From: Simon Davis
Sent: 05 December 2018 15:54
To: Planning.Responses
Subject: FW: BE/88/18/DOC

Further Drainage comments

From: [REDACTED]
Sent: 26 November 2018 16:20
To: Simon Davis
Cc: Christopher Tomkins
Subject: BE/88/18/DOC

Detail: Foul and SW drainage

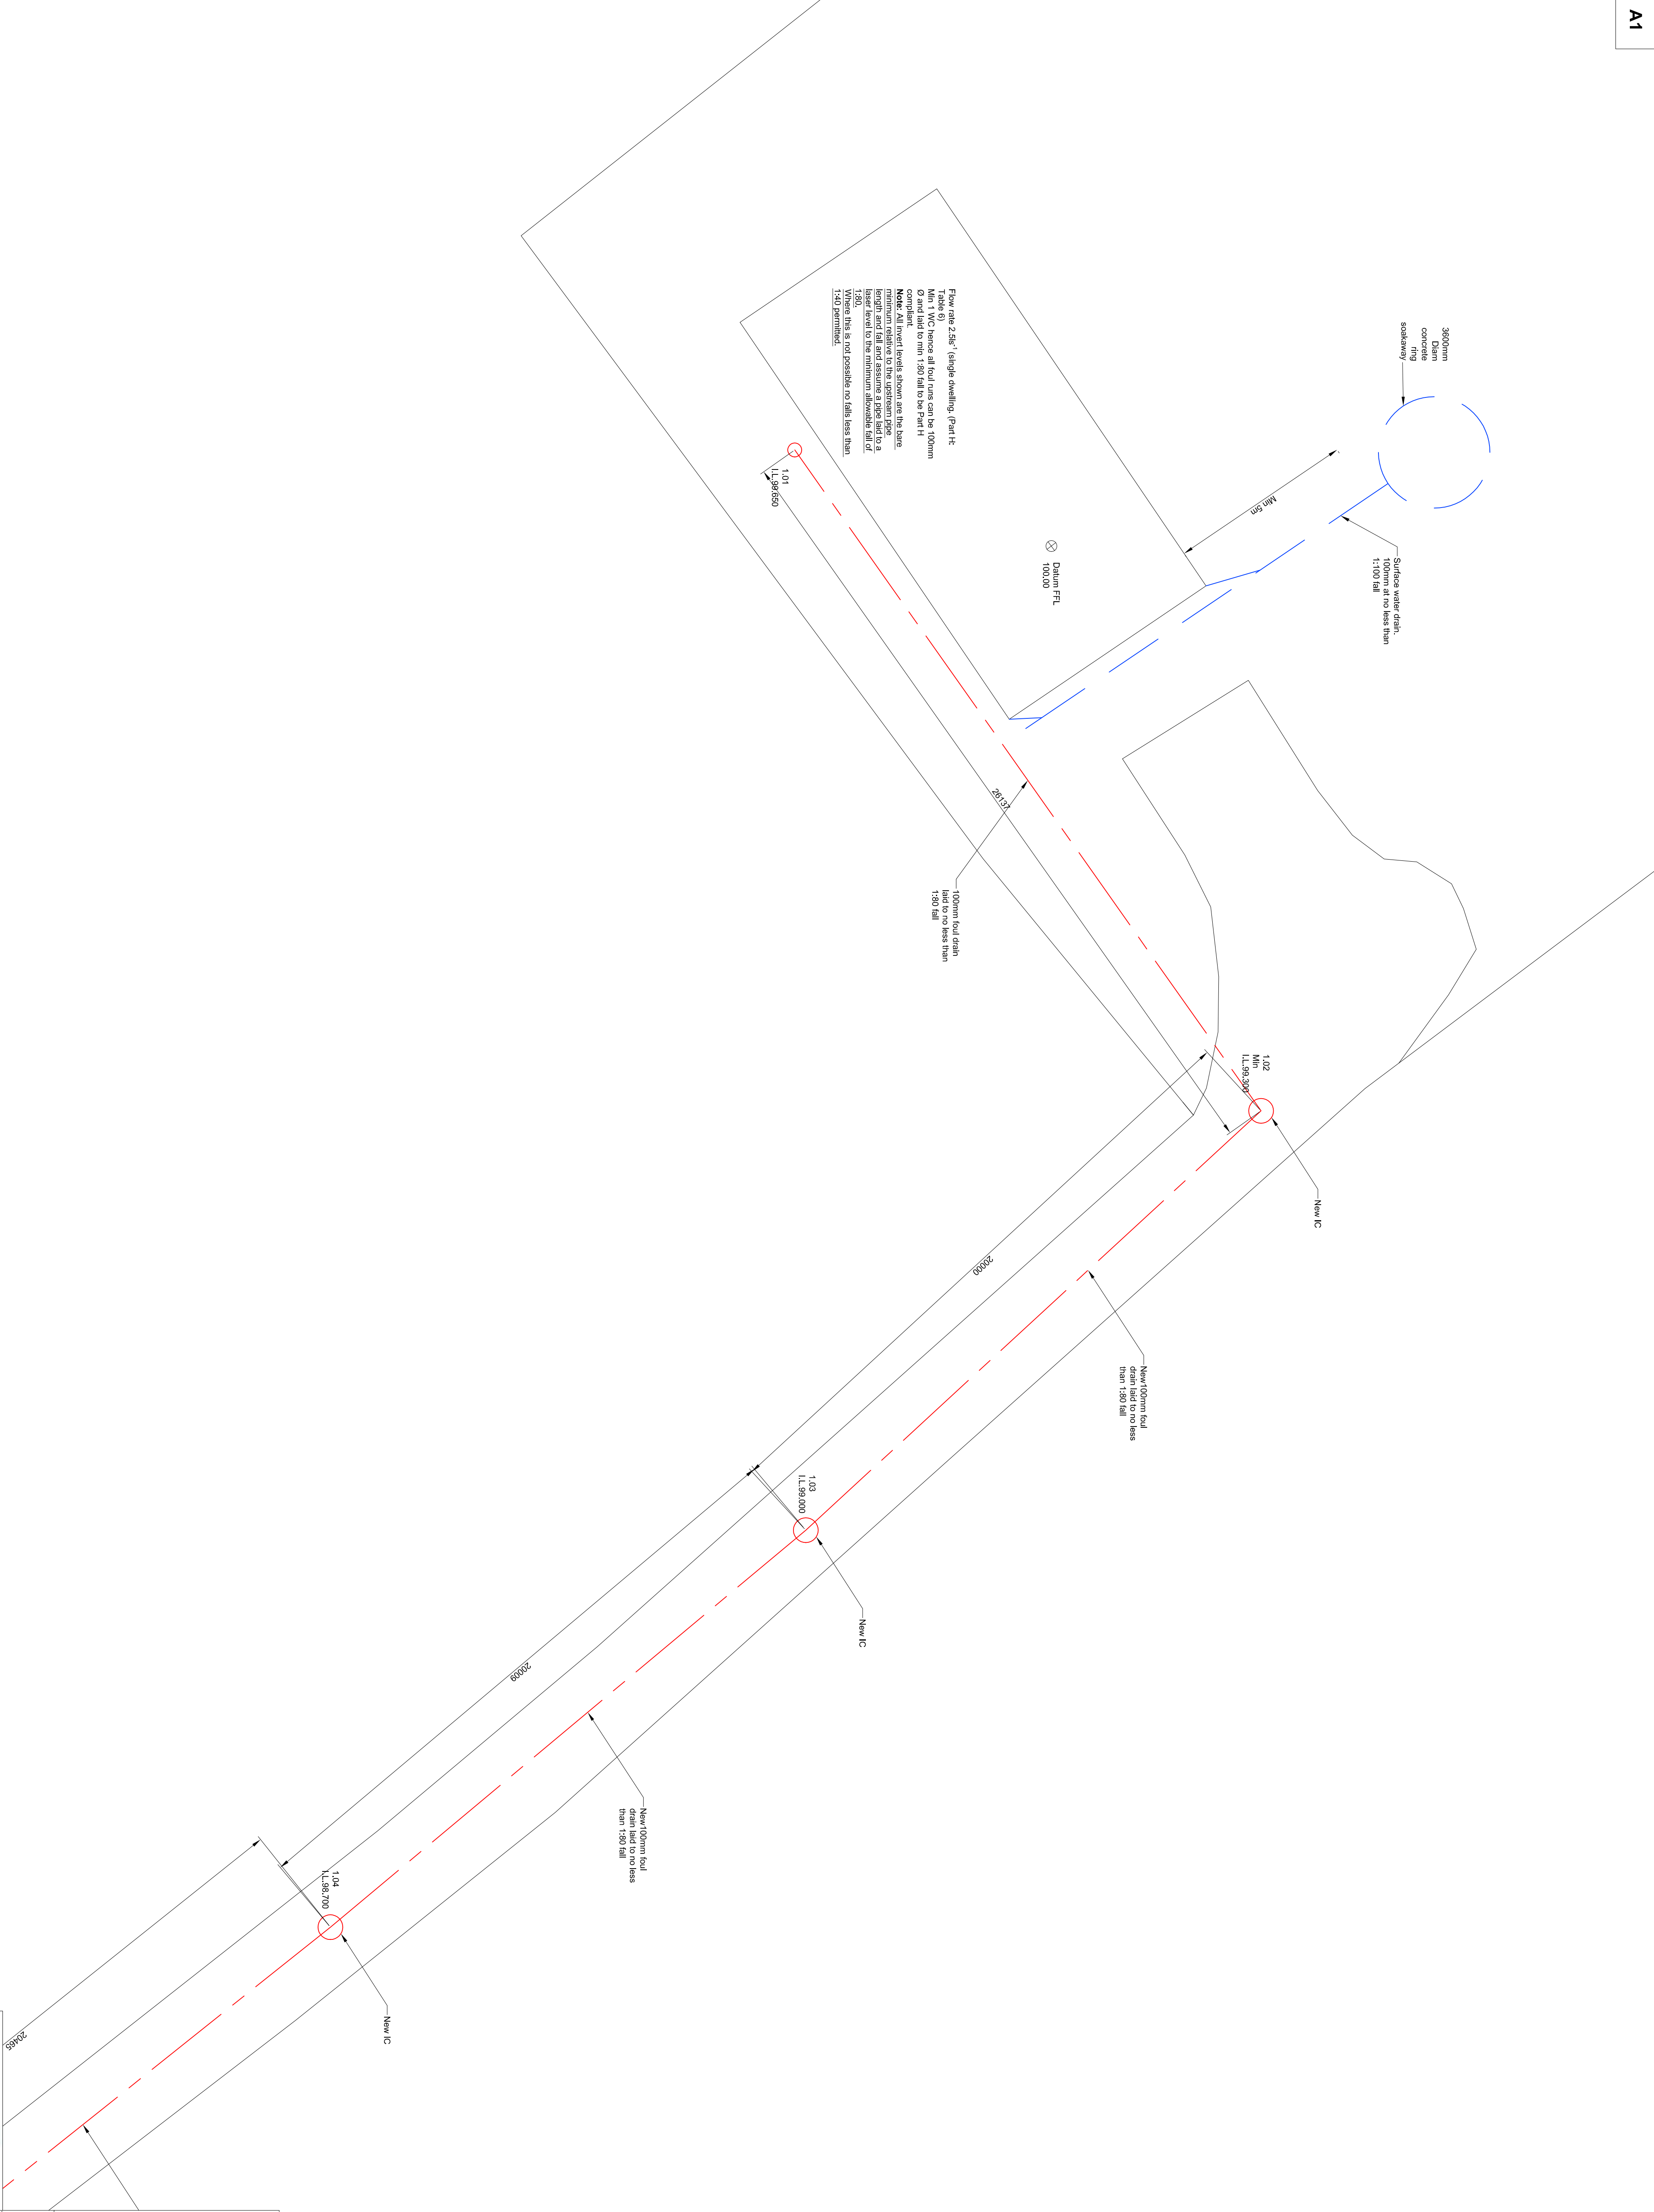
Can they be shown on plan please.

Is this email sufficient or do you need the catchpit and concrete bed & surround showing on a plan?

Back inlet gully will be used for all down pipes for surface water , and as foil drain practice they will be surrounded by concrete.

I can form an interception pit after the two surface water pipes have been joined in a manhole before the pipe enters the soak away crates.
